**STATEMENT OF ENVIRONMENTAL EFFECTS: SECTION 75W APPLICATION TO MAJOR
PROJECT MP NO.10_0107 STAGE 1 (BUILDINGS 1 AND 2) – 61 MOBBS LANE, EPPING**

Pursuant to Section 75W (1) (a) of the Environmental Planning and Assessment Act 1979, a 'modification of approval' is sought to vary Condition No. A2 pertaining to Major Project MP No. 10_0107 as approved on the 17 January 2011. Various modifications are sought to address market demand and construction details applying to Buildings 1 and 2. The changes do not alter the height, bulk or scale of the approved development.

B2 Elevations (A1005) Rev A – South Elevation

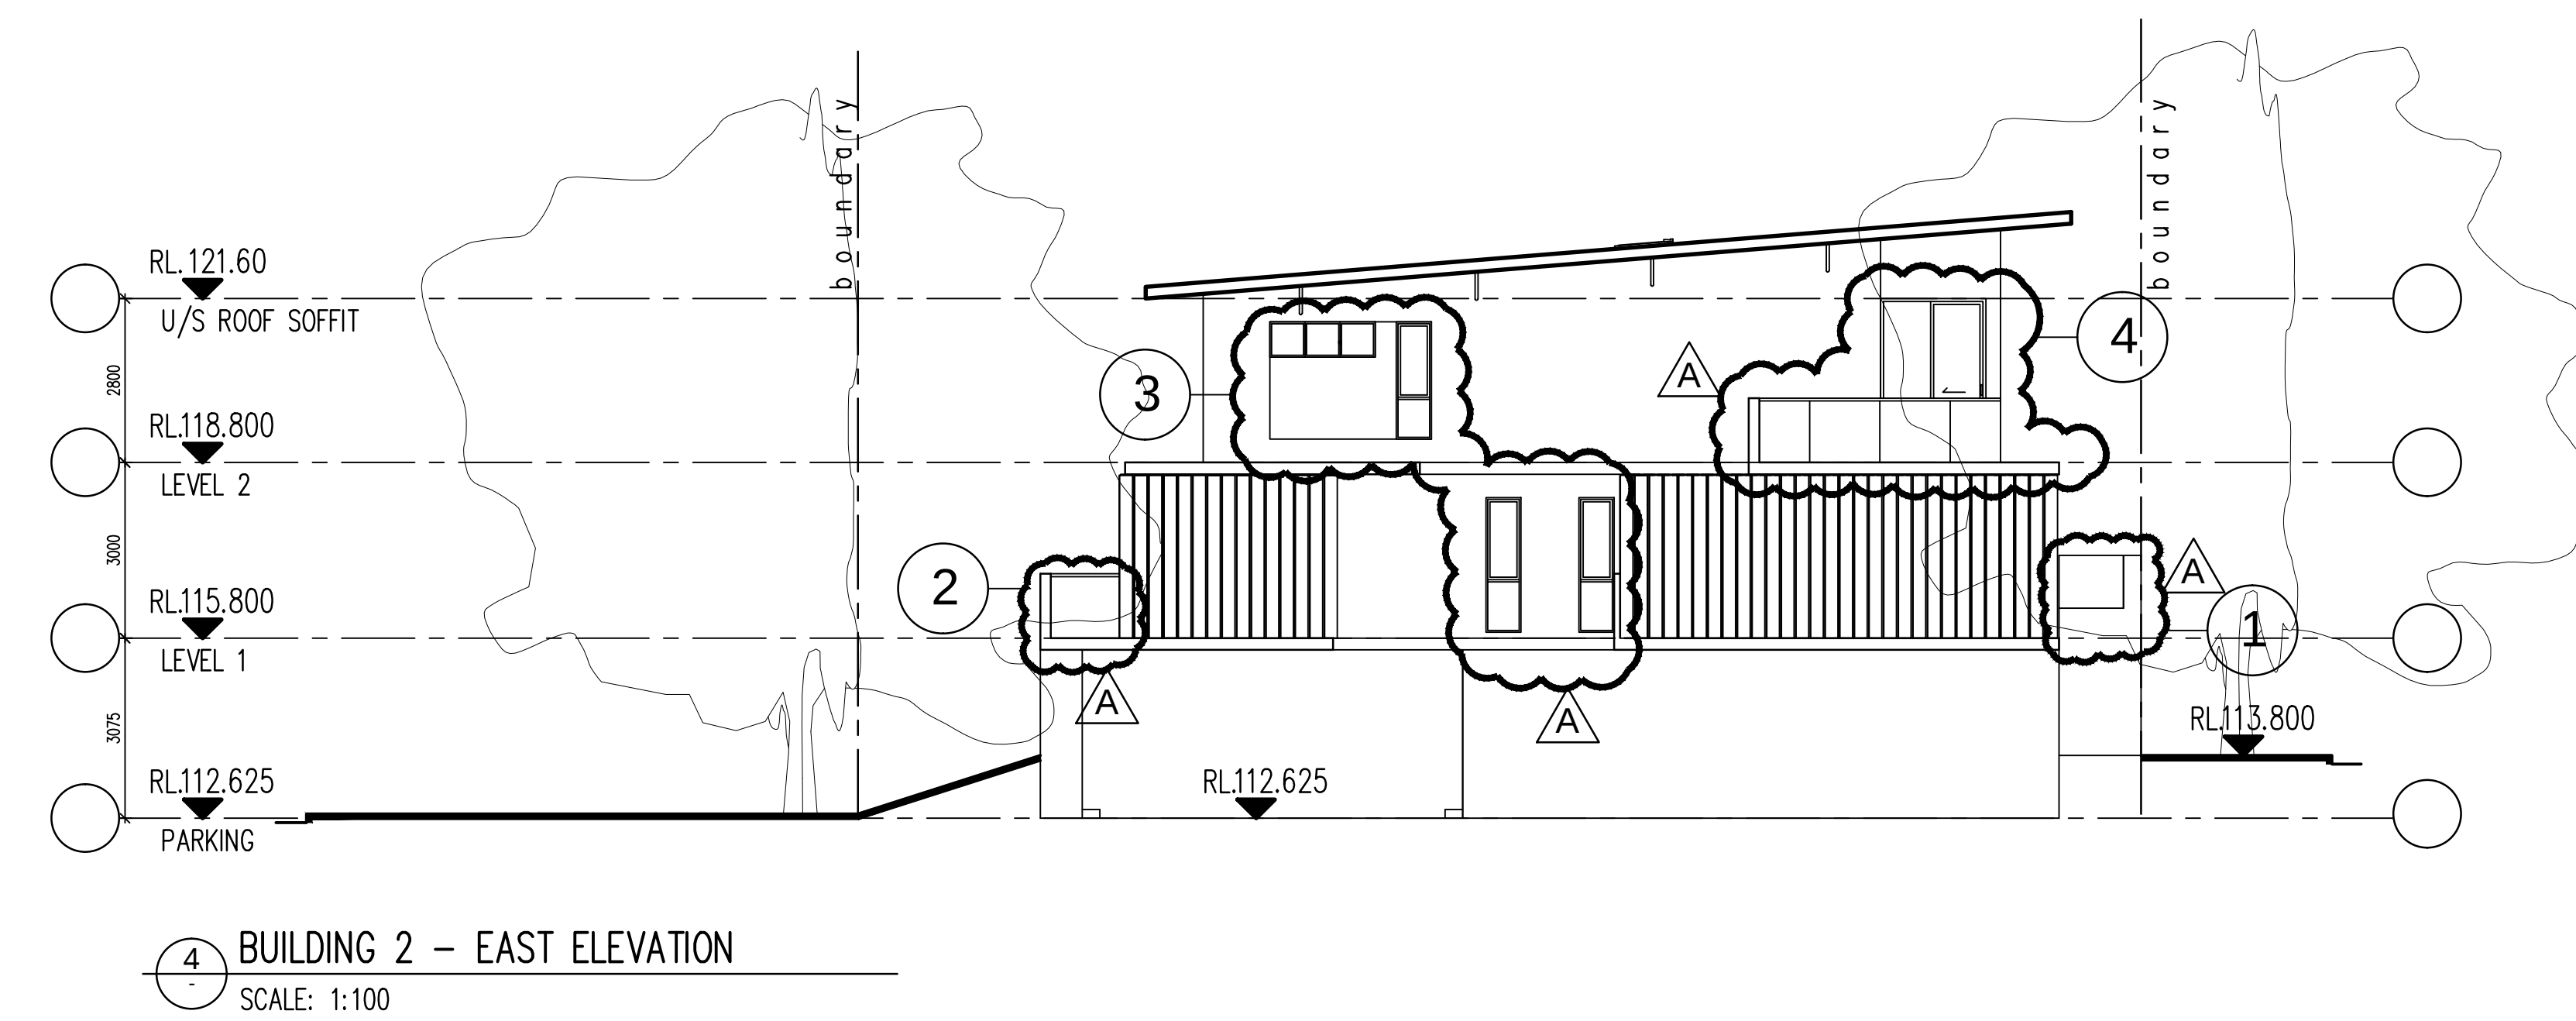
1. New sliding doors and frameless glass balustrades
2. Revised ramp RL.
3. Revised ramp RL.
4. Skylights reduced from 3 to 1.

1. New glass and masonry courtyard fence 1.8m.
2. Frameless glass balustrades.
3. Windows reconfigured.
4. New sliding door and balcony.

B1 Sections (A1006) Rev A

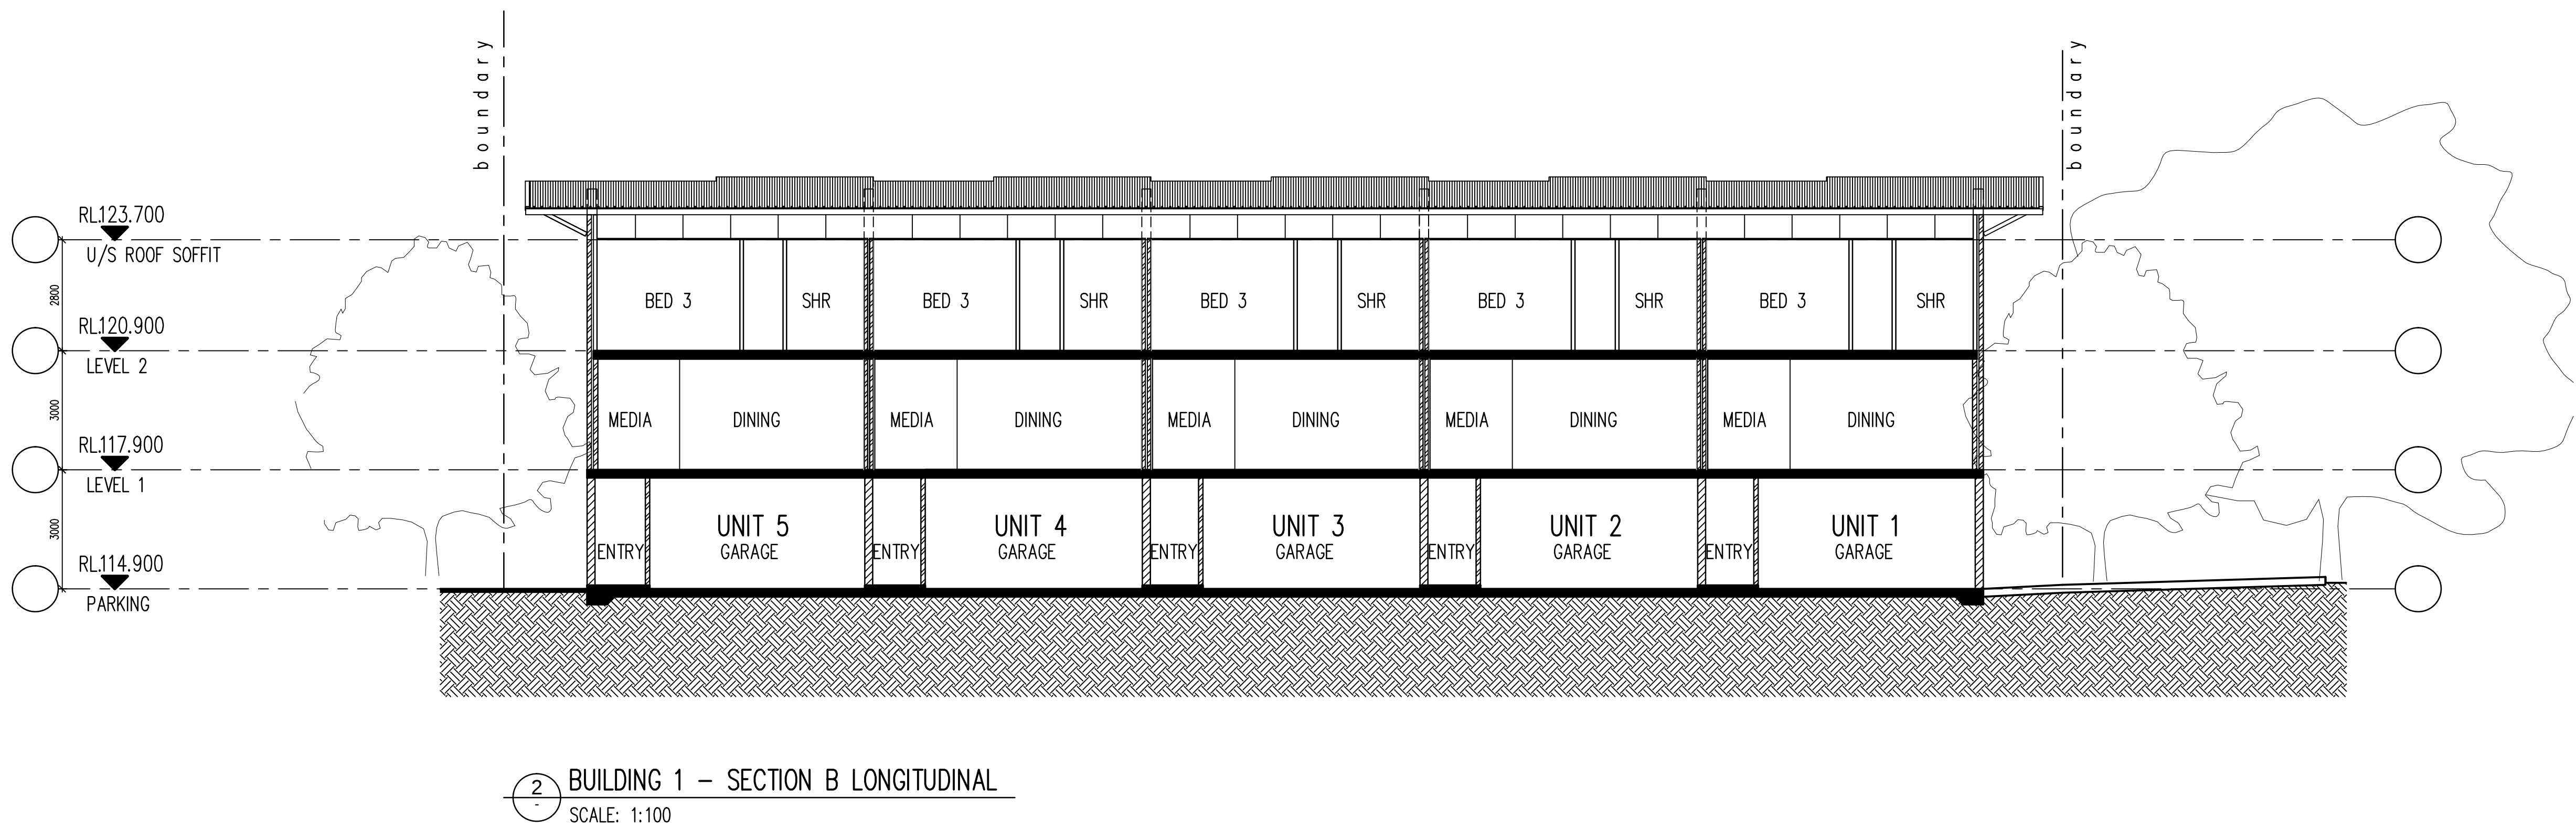
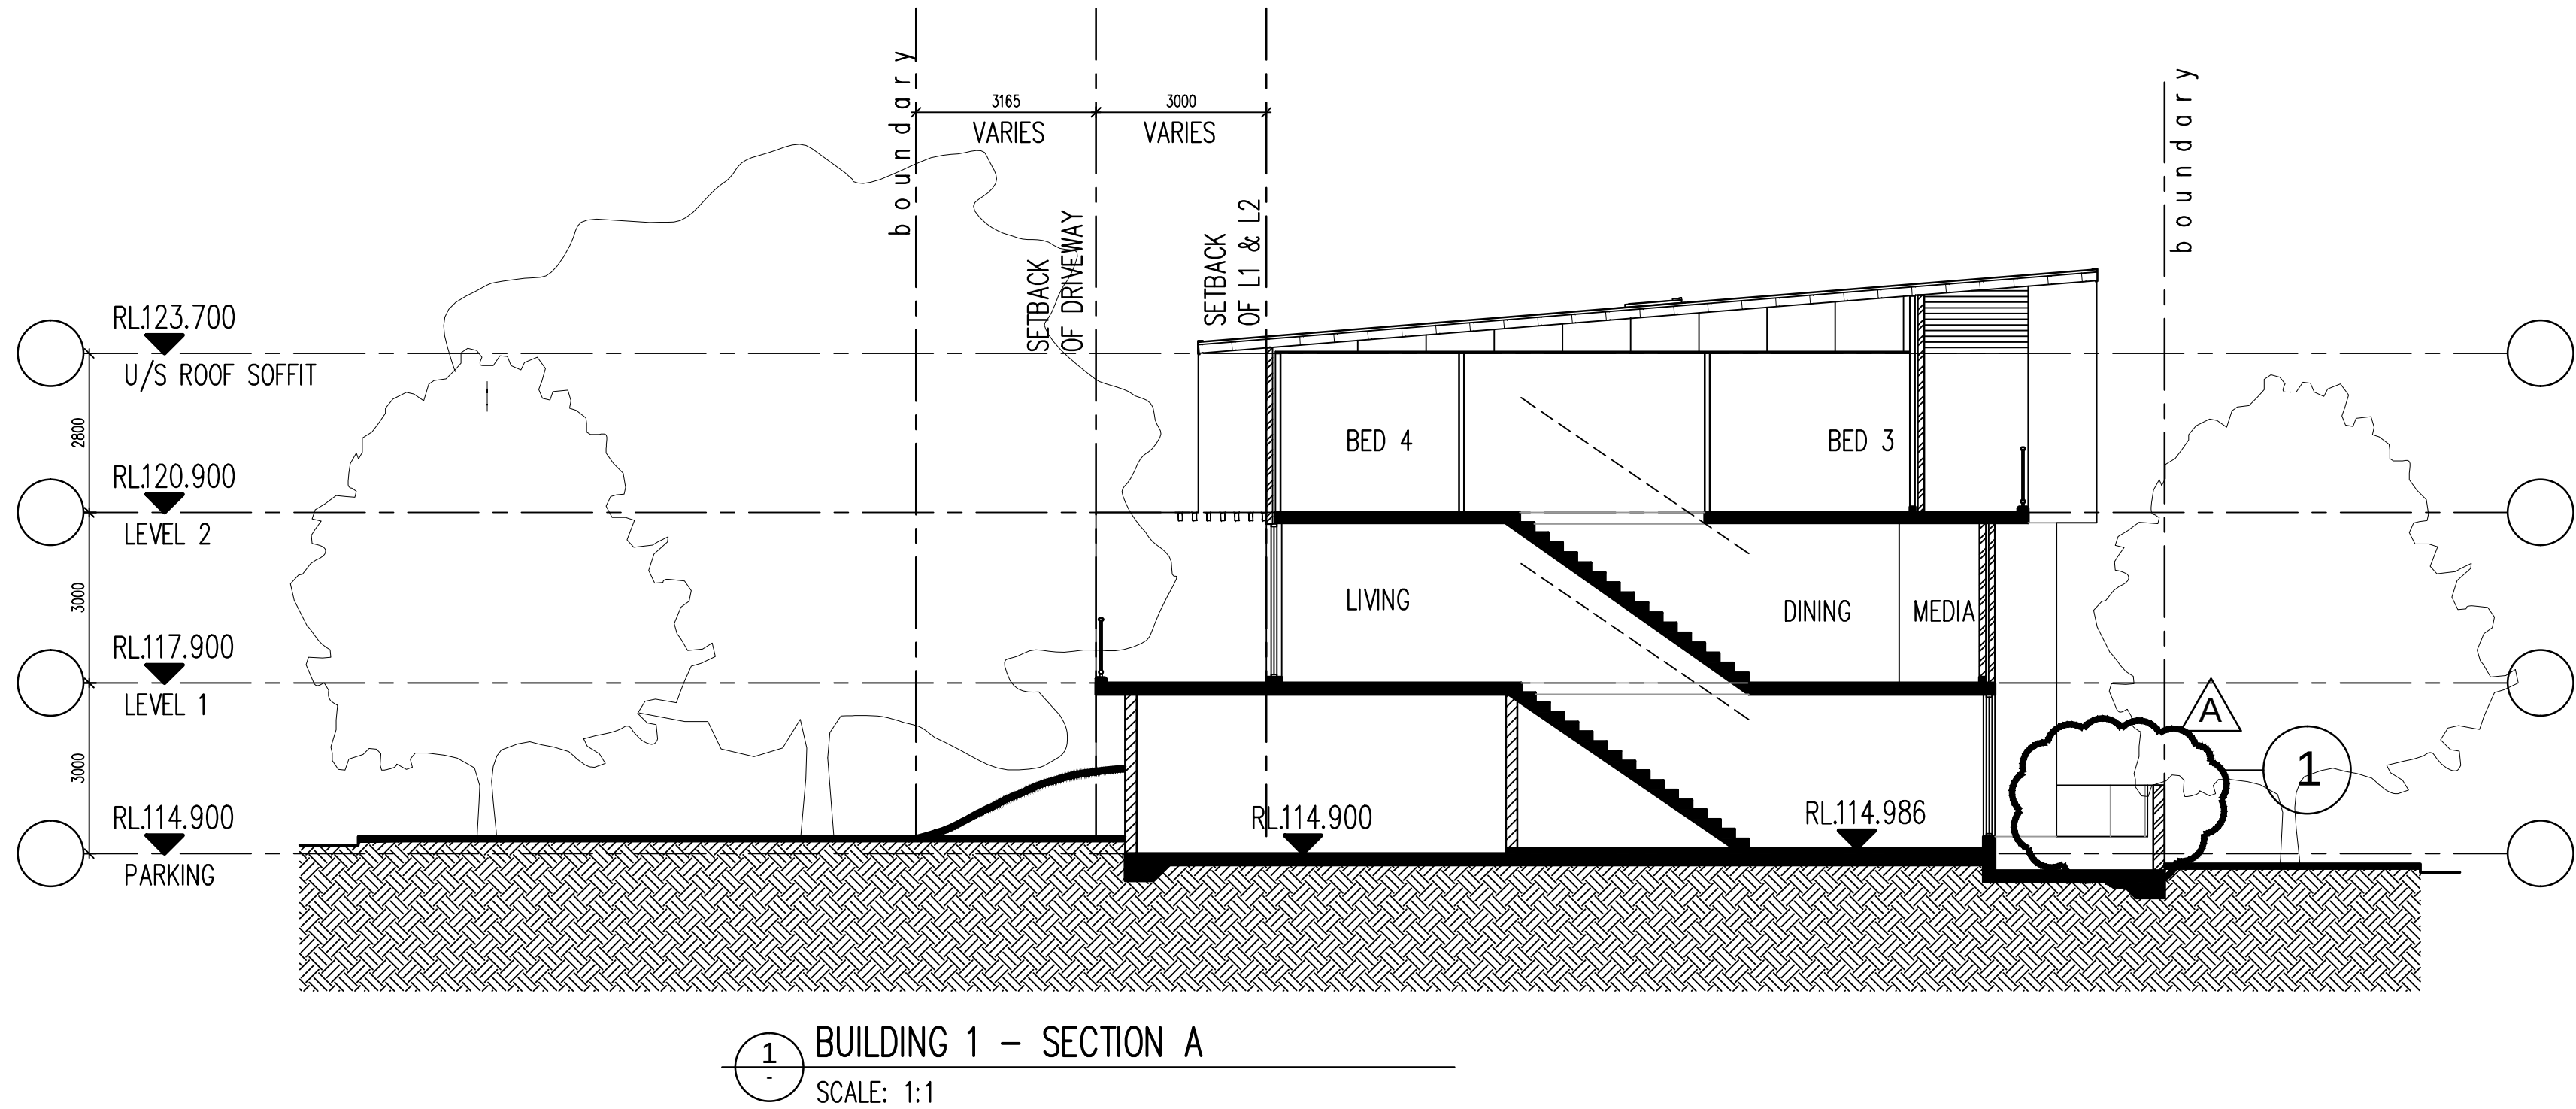
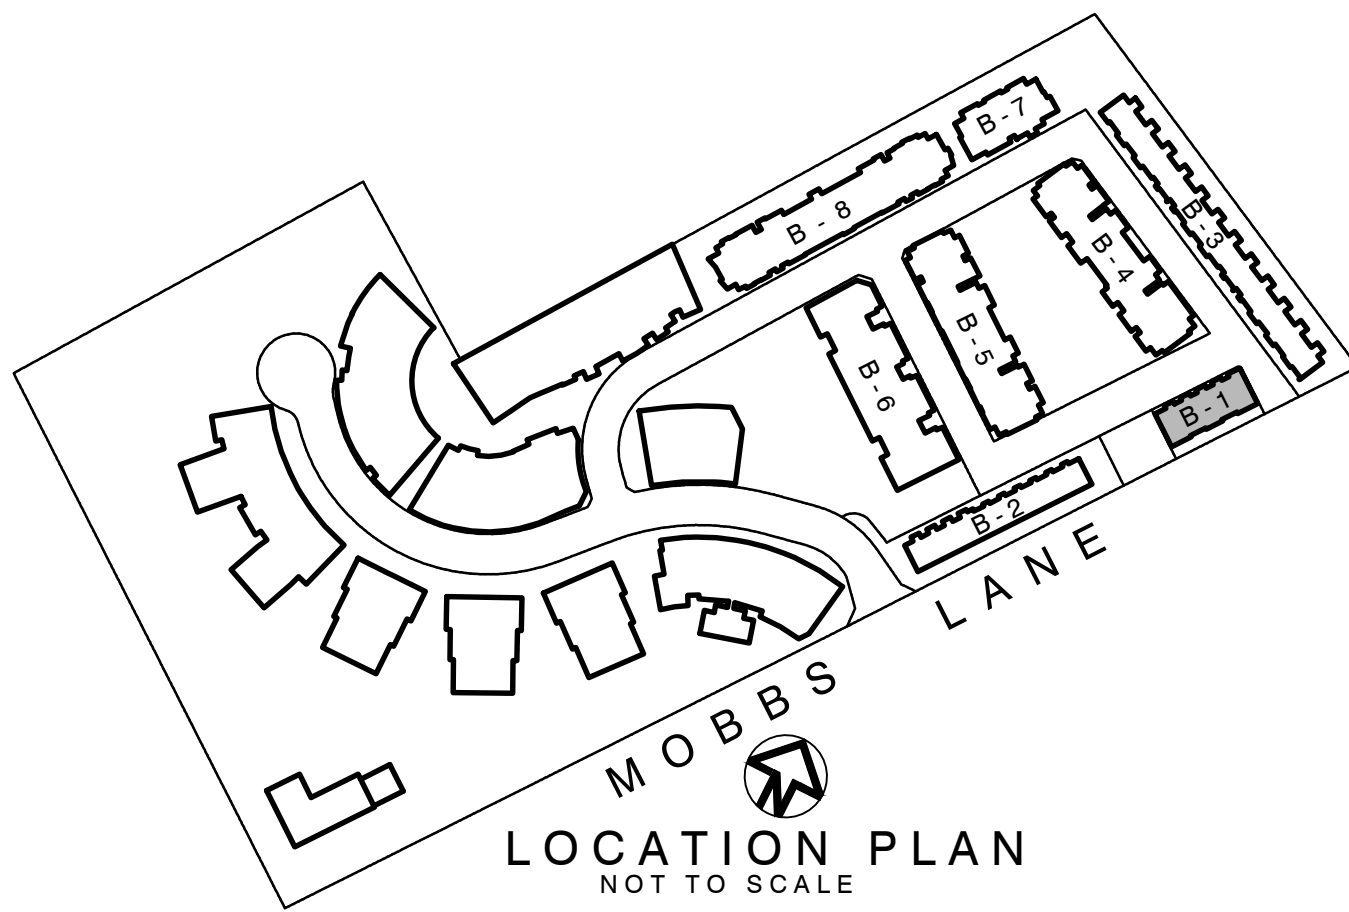
1. New glass and masonry courtyard fence 1.8m.
